**FFERM WYNT ALLTRAETH AWEL Y MÔR ARFAETHEDIG / PROPOSED AWEL Y MÔR OFFSHORE WINDFARM**

**CYFEIRNOD YR AROLYGIAETH GYNLLUNIO / PLANNING INSPECTORATE REFERENCE: EN010112**

**RE: NATURAL RESOURCES WALES' WRITTEN SUBMISSION FOR DEADLINE 3a**

This image provides landscape and visual context only

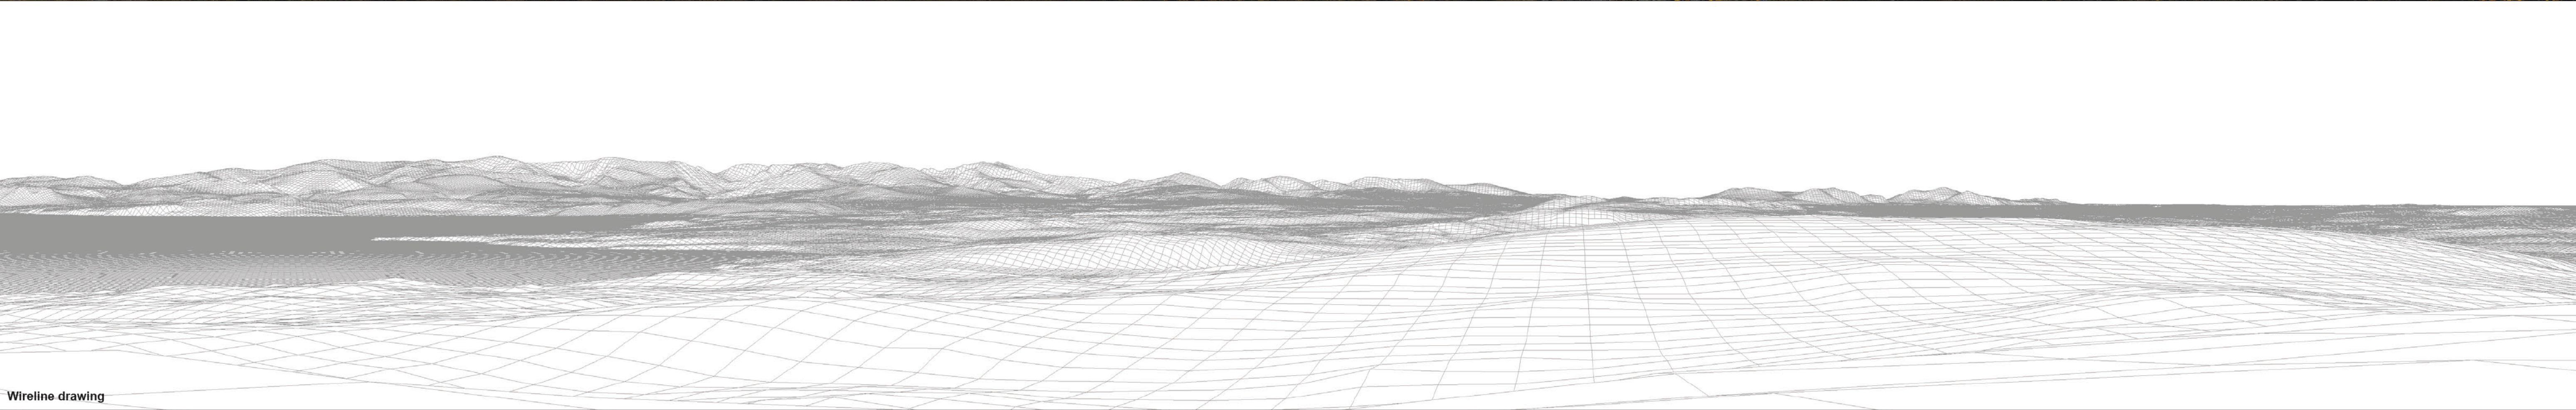
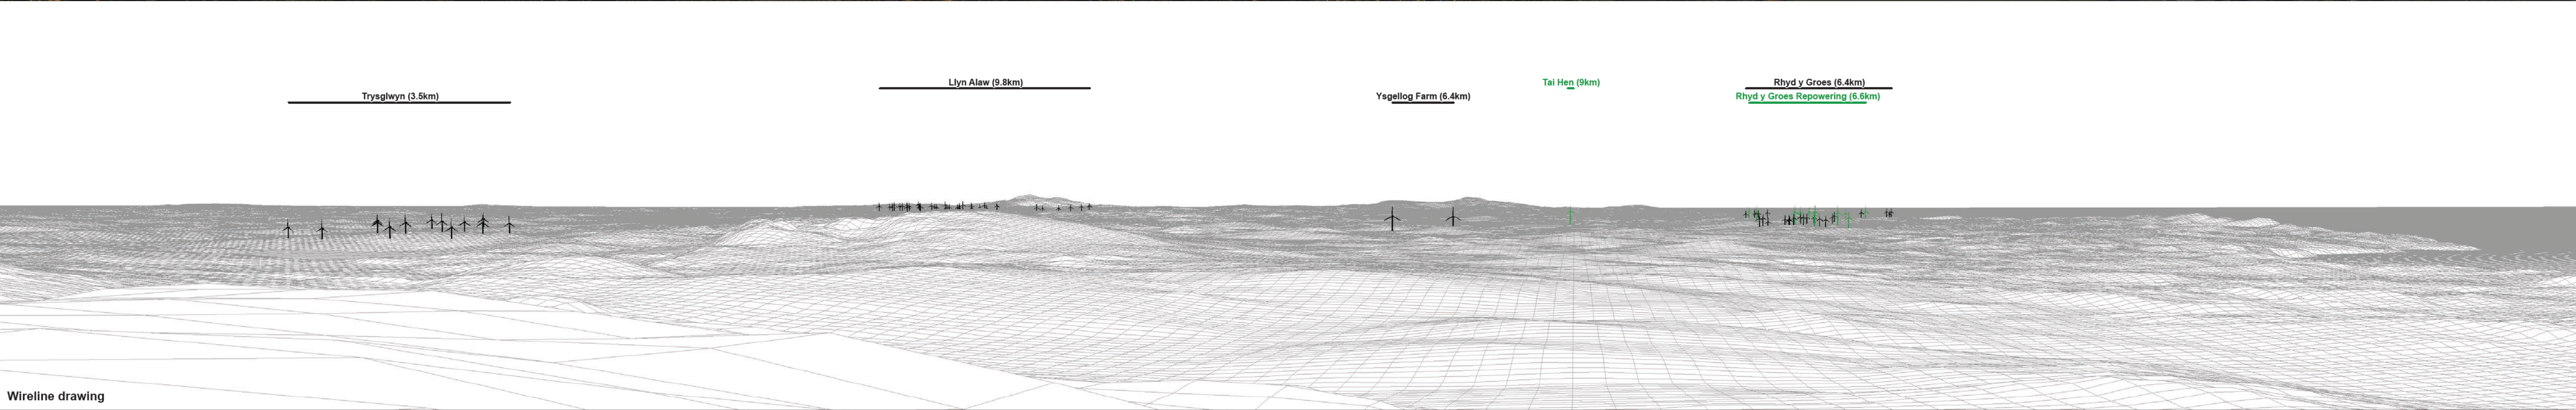
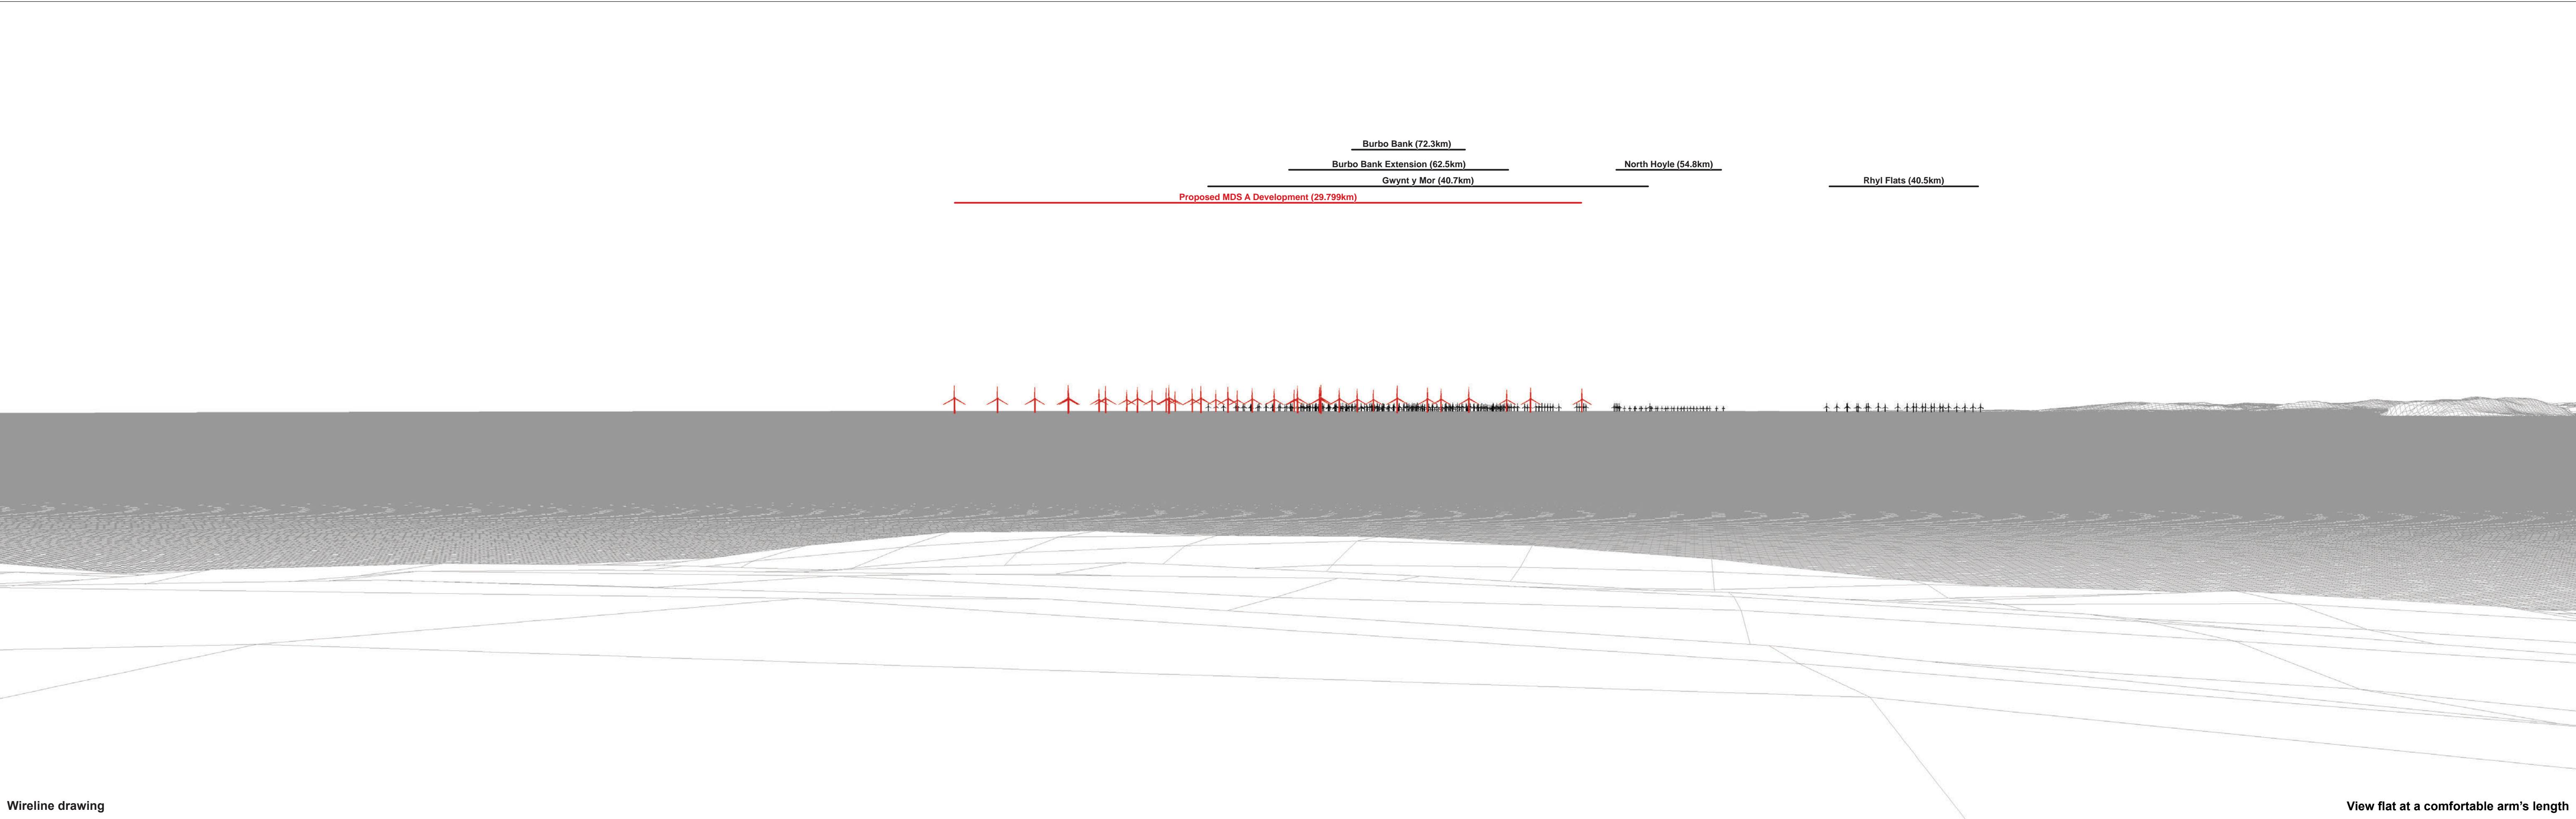
- 2.5. In relation to viewpoints (VP) 1 (Porth Llechog/Bull Bay) [APP-230], VP2 (Trwyn y Balog/ Point Lynas) [APP-231] and VP3 (Mynydd Eilian) [APP-232], we consider that the effects at these viewpoints have been underestimated in the SLVIA. We consider the effects to be of low-medium magnitude, and that this level of magnitude combined with high sensitivity should lead to an assessment of moderate adverse effects, which we consider significant. We consider the threshold for significance has been reached for VPs 1, 2 and 3.

- 2.6. From these viewpoints, highly sensitive receptors (e.g., walkers on the coastal path) are focused on the coastal landscape and sea views. Although there are large-scale sea views, the scale and nature of the development would make it very noticeable and focus attention upon it. Sea views and the coastline are the key focus of views in the predominantly coastal AONB and sea views are currently untrammelled by development or any other significant human activity, apart from the occasional ship. This part of the AONB is relatively remote and tranquil. The existing offshore windfarms to the east, including Gwynt y Môr, are extremely hard to discern even in fine weather and built development along the coastline is not similar in nature or scale to the proposed wind farm. The proposal would interfere with the appreciation of the open sea and coastline including views of coastal landforms and the mountains of Eryri (Snowdonia). Windfarms inland, as seen from Mynydd Eilian, are smaller scale and associated with the inland rural landscape and not sea views and the coastline.
